THE VILLAS AT CLAREMONT RANCH
TRACT G CLAREMONT RANCH FILING NO. 7 &
TRACT A CLAREMONT RANCH FILING NO. 7
EL PASO COUNTY, COLORADO
PUD DEVELOPMENT PLAN & PRELIMINARY PLAN

THE VILLAS AT CLAREMONT RANCH
PUD & PRELIMINARY PLAN

DATE: 12.23.2020
PROJECT MGR: A. Barlow
PREPARED BY: J. SHAGIN

Final Landscape Plan

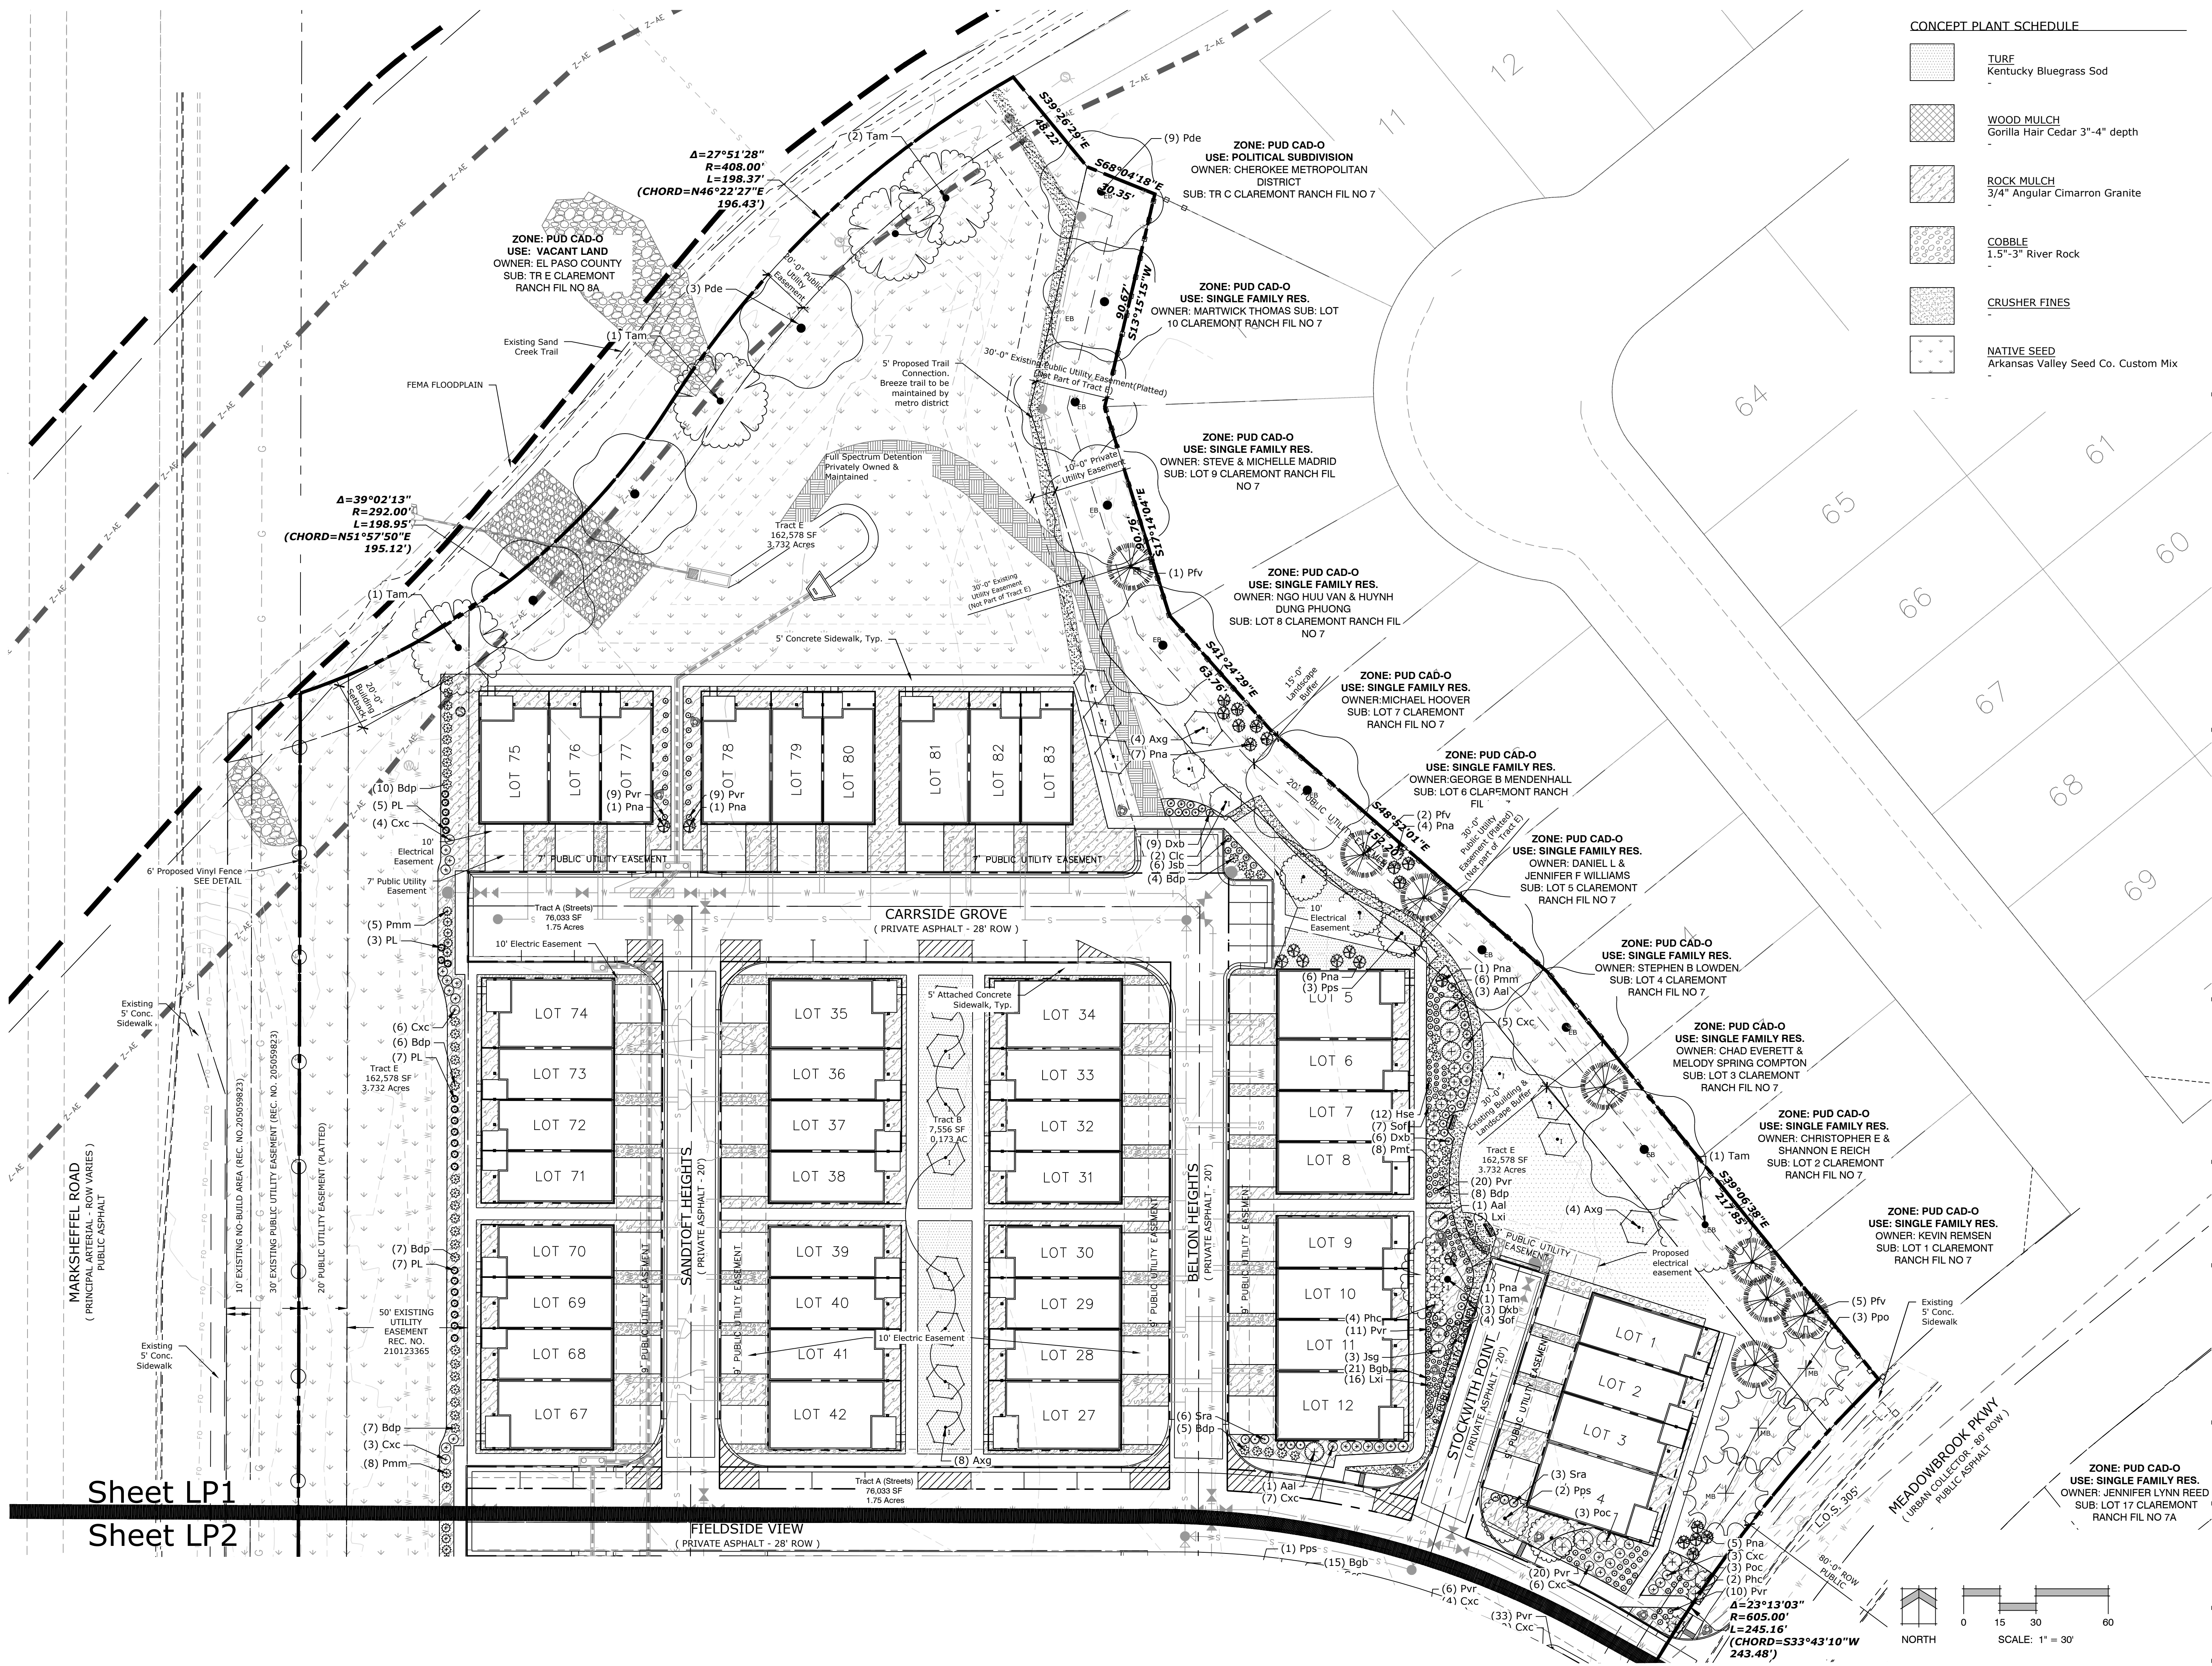
Is this the 5 ft noise wall? Does this surround the entire property? 5 ft noise wall is indicated to only be on west side but this appears to surround property.

Fence has been updated to reflect proposed 6' vinyl fence
